Re: 4th Site Development Plan Review, King Soopers #147 – Falcon Market Place

Please find below our re-submittal package addressing the comments received on September 11, 2020. To facilitate your review, we have included the original comments in italicized font, and have provided our responses in **blue**.

King Soopers #147 – Falcon Marketplace
E. Woodmen Rd. & Meridian Rd.
October 5, 2020

C1.0

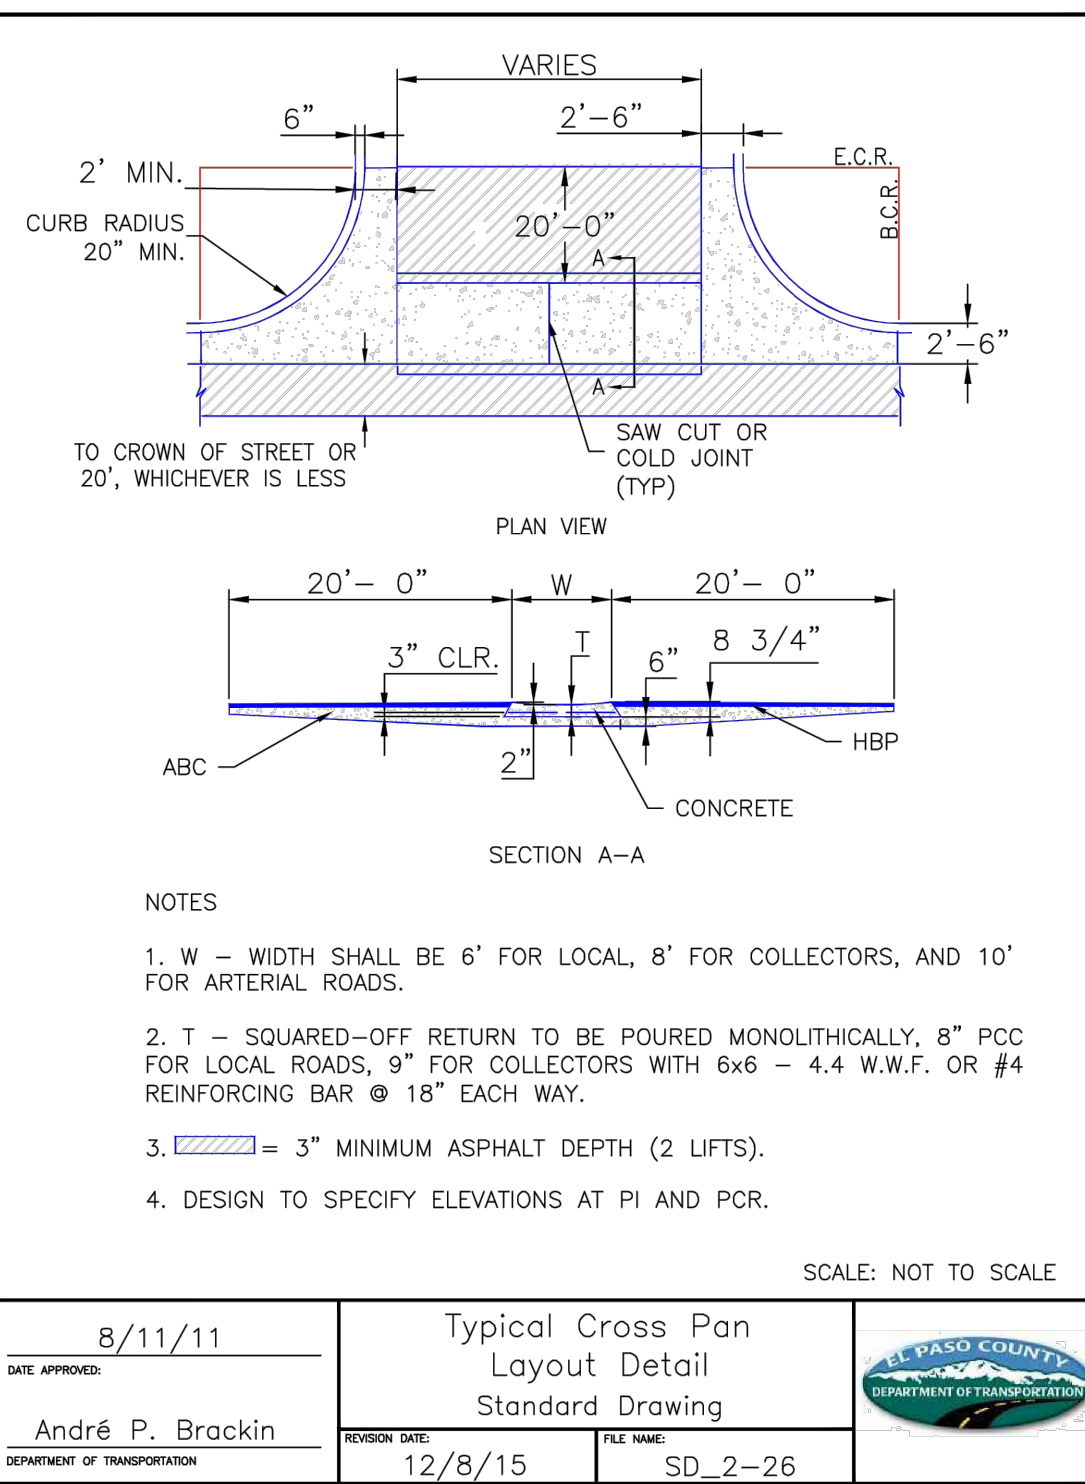
Regarding a request for approval of a site development plan within Falcon Marketplace, Enumerations has the following comments: 1. The drive aisle between Lots 4 & 5 is shown with the street name of Falcon Market Place. This is an unnamed drive aisle and the name should be removed. Brent Johnson Enumerations Plans Examiner Pikes Peak Regional Building Department O: 719-327-2888 E: brent@pprbd.org W: pprbd.org

✓ Minimum size for loading space is 14' x 40' each. Include waiver request of LDC Sec. 6.2.5(E), requesting 12 ft where 14 ft is required and include justification.

Galloway Response: The street name has been removed from the drive aisle between Lots 4 & 5.

Galloway Response: Added note to this plan stating that a waiver is being requested for loading space size.

C1.2

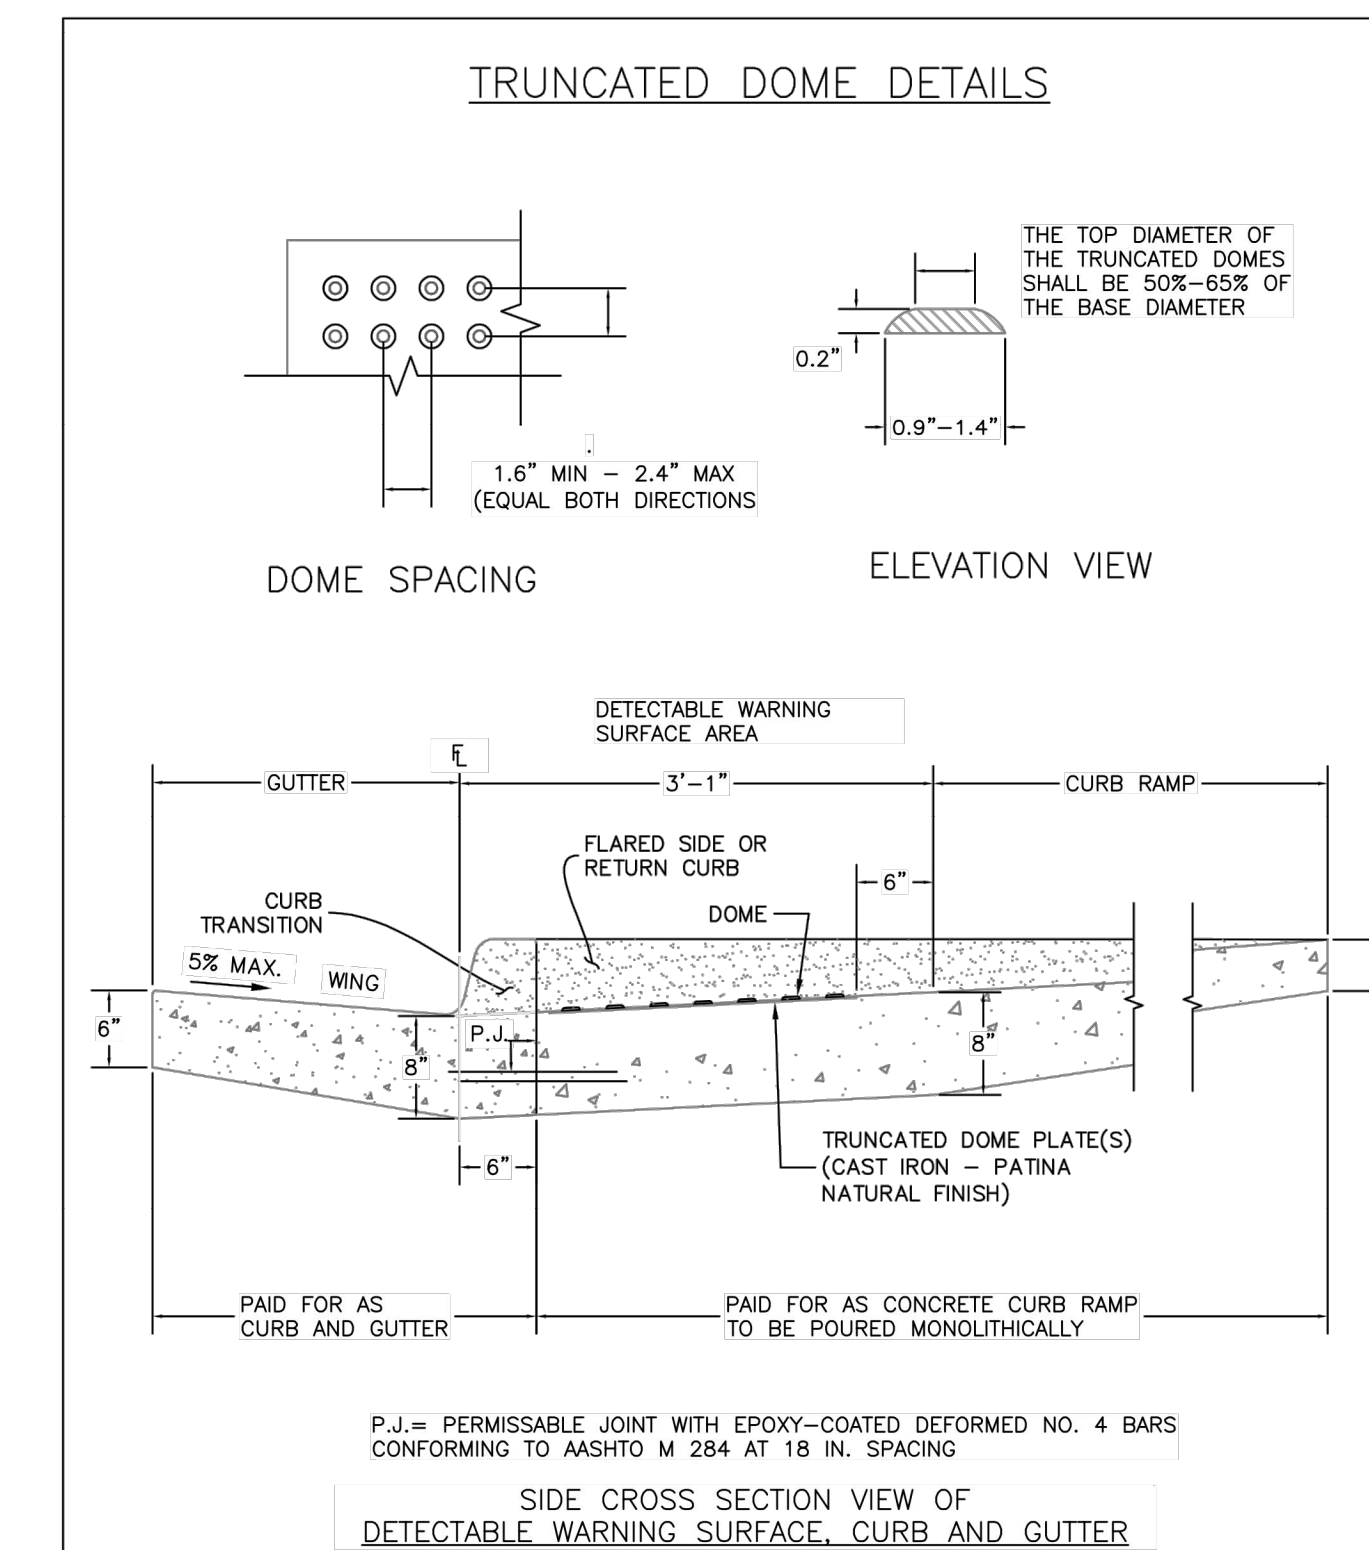
See FAE redlines (delete non-subdivision utility improvements) - See photometric plan redlines provided with SF19001 comments (focus was on roundabout lighting). - Details 2 and 3 on Sheet C1.2 of the Site Development Plan should be updated with the newly adopted details if it is desired to include them. A link to the new ECM Chapter 6 and details can be provided by email upon request. - Provide GEC Plan with all sheets PE-signed and stamped. - Note: A license agreement for landscaping in the right-of-way will be required. A draft template can be provided upon request. Note: Outstanding issues with the subdivision, including final CDs and LOMR need to be completed prior to approval of this SDP. -- Jeff Rice - 719-520-7877

Galloway Response: FAE redlines have been addressed. Photometric plan redlines have been addressed. Details 2 & 3 on Sheet C1.2 have been updated. The GEC Plans are now signed and stamped. Per email from Jeff Rice on 9/29, a recorded license agreement already covers the area of concern for the landscaping within the right-of-way.
